From: Tom Errico <thomas.errico@tylin.com>
To: Helen Donaldson <HCD@portlandmaine.gov>
CC: David Margolis-Pineo <DMP@portlandmaine.gov>, Katherine Earley <KAS@portlandmaine.gov>, Jeff Tarling <JST@portlandmaine.gov>, "JeremiahBartlett" <jbartlett@portlandmaine.gov>
Date: 4/8/2015 2:36 PM
Subject: Century Tire Plaza – 195 Kennebec Street

Nell – The following represents a status update of my March 24, 2015 comments and is based upon materials submitted by the applicant on April 1, 2015.

DRAWN: ADJ DATE: 11.25.14
DESIGNED: ADJ SCALE: 1" = 20'
CHECKED: ADJ JOB NO.: SP-M160
FILE NAME: SP-M160 BASE
SHEET: **C-3.0**

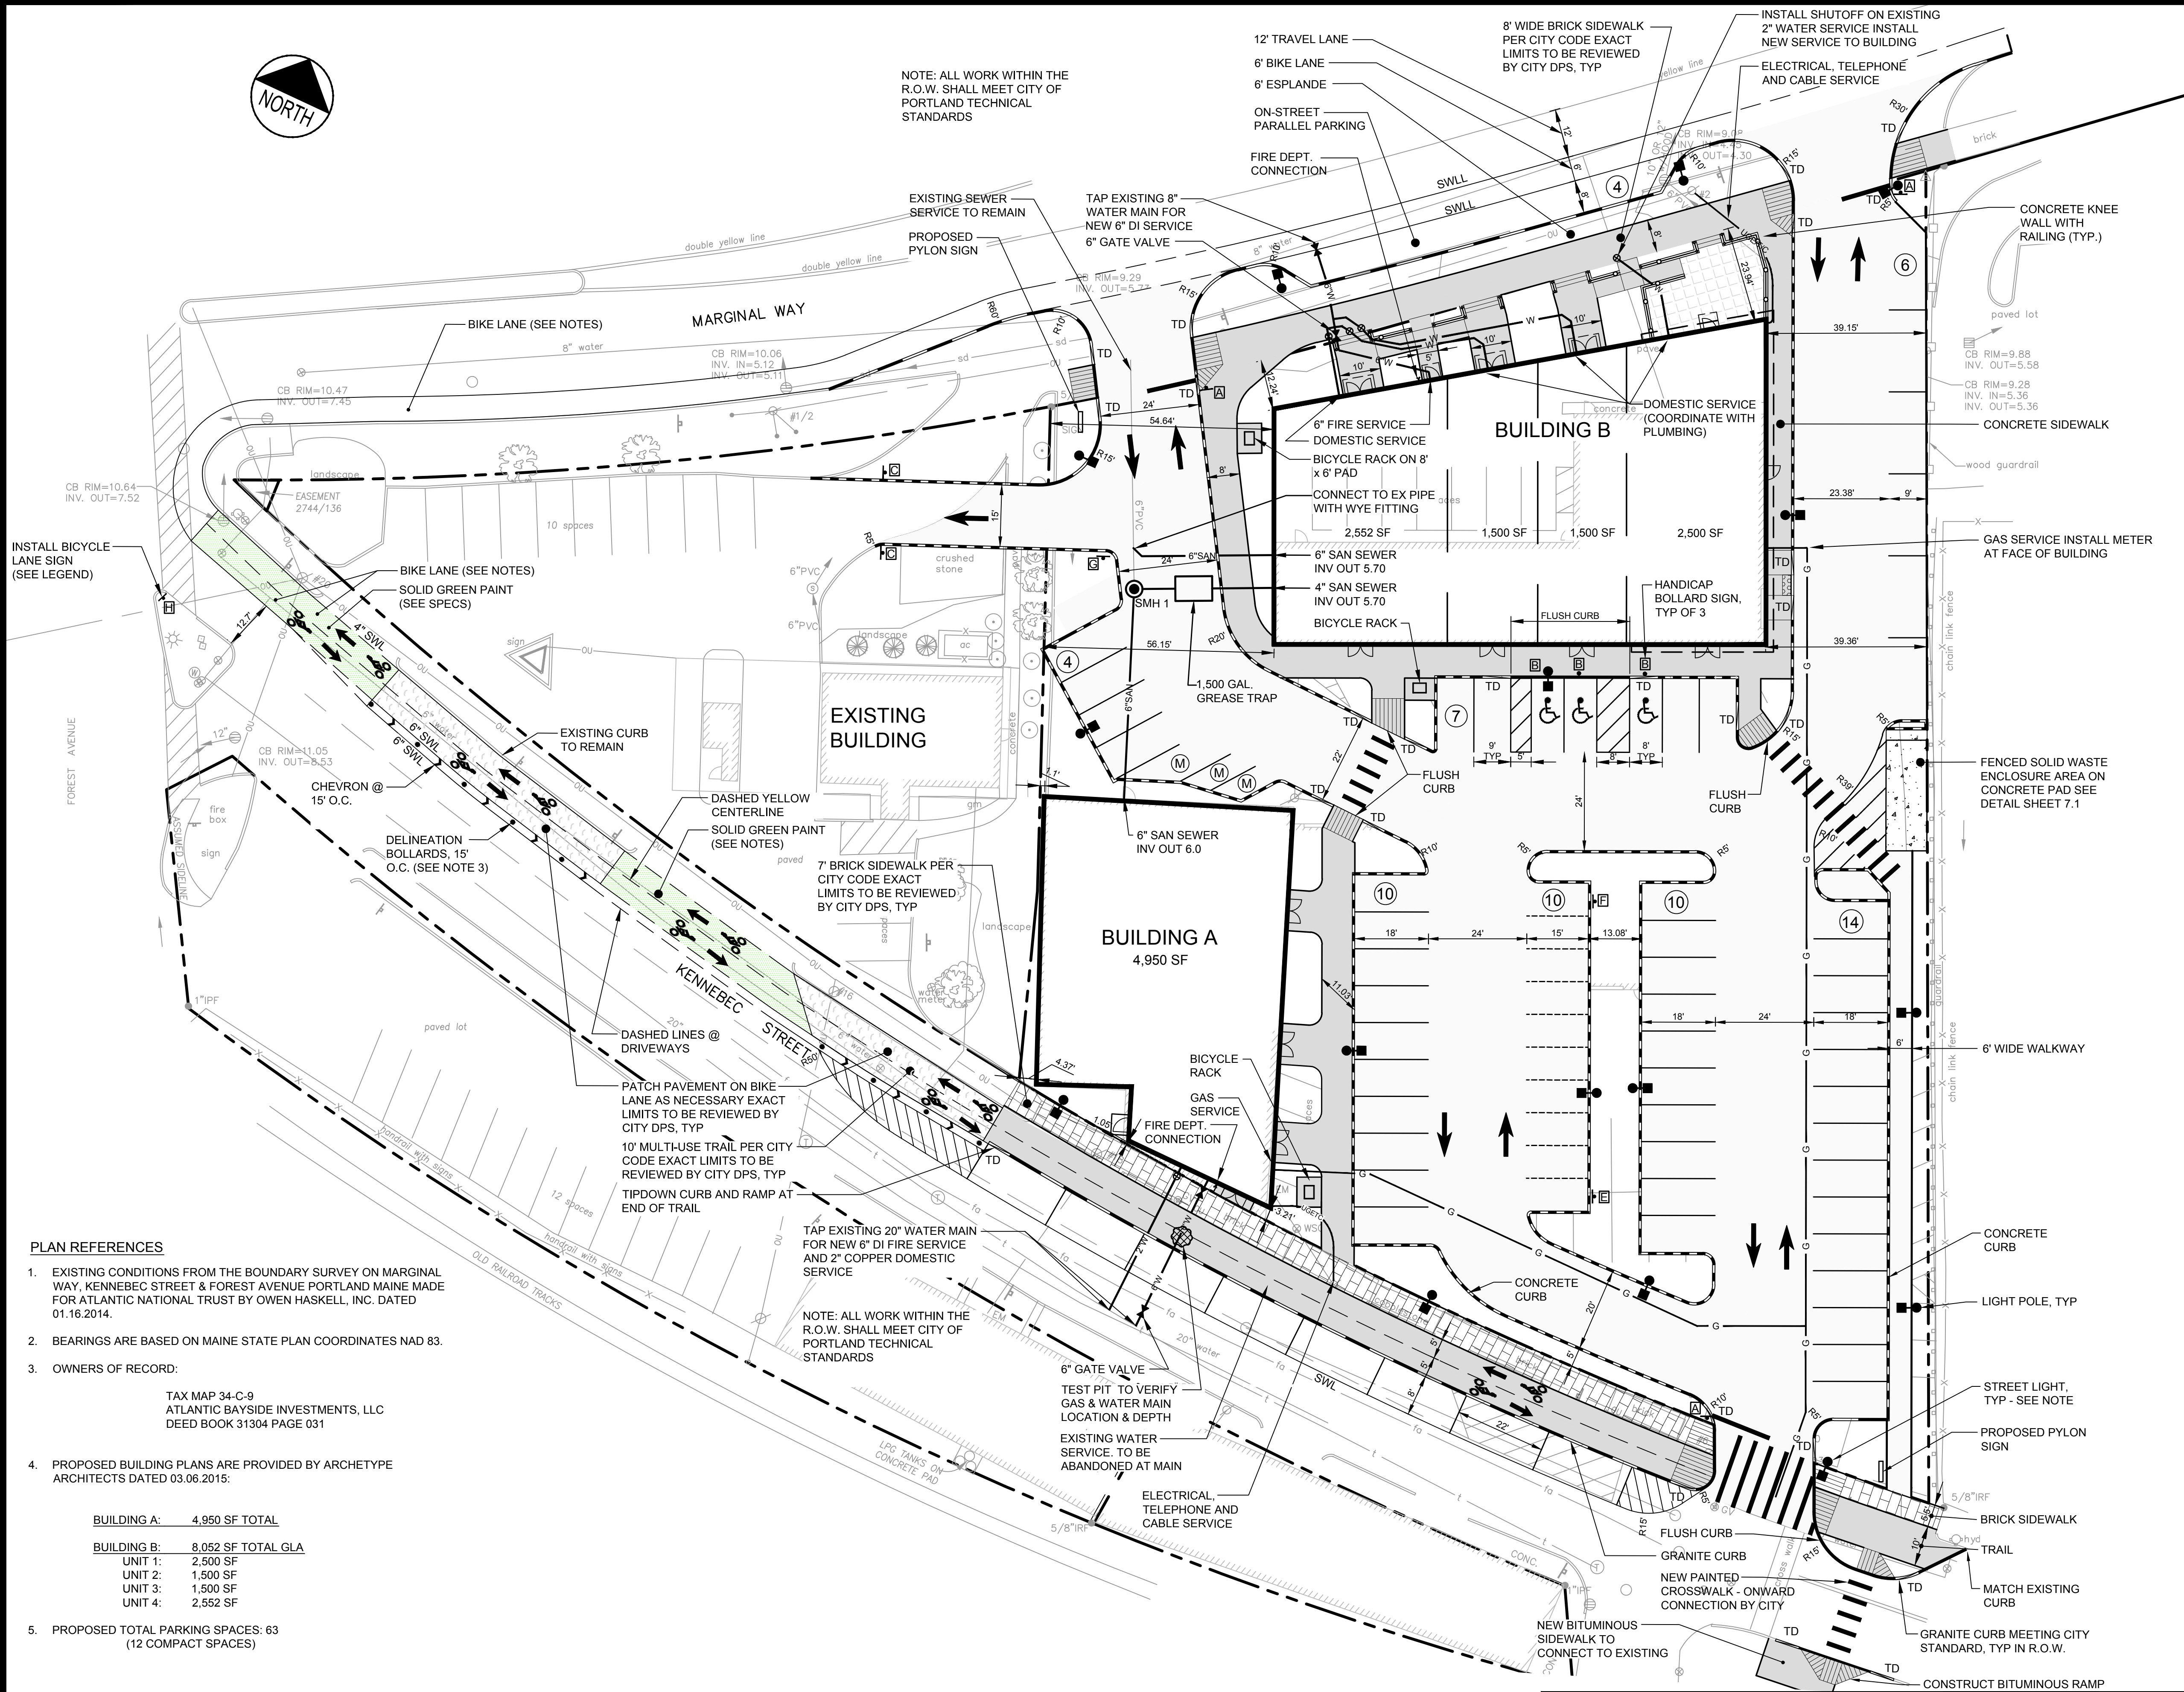
1. The project frontage on Marginal Way shall be adjusted to meet the design principles of the Marginal Way Master Plan (the nearby Gorham Savings Bank Building is a good example). The plans should account for the following:

- On-street parking

- The curb line should extend into Marginal Way and generally match the curb line at the Gorham Savings Bank site. The applicant should be cognizant of the transition from Forest Avenue and how vehicles will be aligned.

- 10-foot brick sidewalk

- 6-foot bicycle lane

Status: Based upon further review and a desire to have a more substantial esplanade area, the sidewalk width shall be reduced to 8 feet and the esplanade expanded by 2 feet. This will match more closely with the Gorham Savings Bank frontage. I would also note that a curb extension west of the westerly driveway shall be provided that matches the east corner. Transitional pavement markings will be required for bicycles and vehicles from Forest Avenue. A plan shall be provided for review and approval by the City.

2. The number of driveways provided for the site exceeds those allowed under the City's Technical Standards. From an access management perspective, I'm most concerned about conditions on Marginal Way. Please noted the following:

- Marginal Way traffic conditions, particularly with the influence of Forest Avenue, does concern me as it relates to the westerly driveway. My preference would be to eliminate this driveway, but recognize its importance for Enterprise access needs. A right-turn entry and exit driveway scenario would help to ease my concern regarding traffic impacts, but this configuration would eliminate Enterprise left entry movements, which I suspect would be problematic.

- The easterly driveway is acceptable to me as the primary driveway although it is suggested that a formal direct pedestrian connection between Marginal Way and Kennebec Street be incorporated.

Status: Given improvements to existing conditions and the incorporation of a shared driveway with Enterprise Rental, I support a waiver from the City's Technical standards for exceeding the number of driveways from the site. I would note that a condition of approval shall be included that requires the westerly driveway on Marginal Way to be revisited during redevelopment of the Enterprise Rental site. I would further note that I find the pedestrian connection to be acceptable. The plans should include a provision that prevents parked vehicles from encroaching on the sidewalk.

6. The frontage on Kennebec Street shall be adjusted to meet the design principles of the Somerset Street Extension project. The plans

- A 10-foot shared use bituminous path to be located next to the granite curb.
- A 7-foot brick sidewalk along the property boundary.
- On-street parking will not be permitted.
- Transition of the shared use path to an on-road cycle track on both ends of the project will be required.

Status: I find the plan to be acceptable with the following notes:

· On-street parking will be permitted on Kennebec Street. Changes to on-street parking regulations will need to be incorporated into the City's Traffic Schedule and therefore will require City Council approval. The applicant will be required to provide supporting documentation in support of the request.

· A curb extension shall be provided on Kennebec Street at the location of the sidewalk ramp/crosswalk such that the handicap ramp is not located within the 10-foot path area. The applicant shall submit plans for review and approval by the City.

· The applicant shall be required to install pavement markings, signage, and bollard treatment in conjunction with the transition from the 10-foot shared-use path to an at-grade cycle-track facility to Forest Avenue. The City will work with the applicant in the development of the plan for this work. It should be noted that this change will maximize on-street parking along Kennebec Street in front of the Enterprise Rental Site.

7. The applicant should investigate the possibility of aligning the driveway on Kennebec Street with Brattle Street.

Status: Based upon current traffic conditions on Kennebec Street the proposed alignment is acceptable. I would note that a condition of approval should be included that revisits the design and location of the subject driveway during the redevelopment of the Enterprise Rental site.

8. Stop bar locations shall be placed prior to sidewalk at the driveways.

10. The plans should incorporate a full ADA compliant crosswalk on Kennebec Street between the site and Brattle Street (this crosswalk currently exists).

Status: The plans should also include the construction of a ADA compliant ramp on the south side of the crosswalk on Kennebec Street. Plans shall be provided to the City for review and approval.

11. The configuration of the six parking spaces located along the Enterprise property boundary are non-standardized and dimensional standards are unclear and I would prefer a more traditional layout.

Status: The applicant shall revise the configuration of these spaces to conform to standard parking space orientation. Plans shall be provided to the City for review and approval.

· I support a waiver from the City's Technical standards for circulation lane widths (20 feet, 22 feet, and 23.38 feet are proposed).

· It is unclear how ADA/pedestrian building access will be provided along the Marginal Way frontage. Details shall be provided that confirm ADA accessibility and reasonable pedestrian access provisions are to be provided.
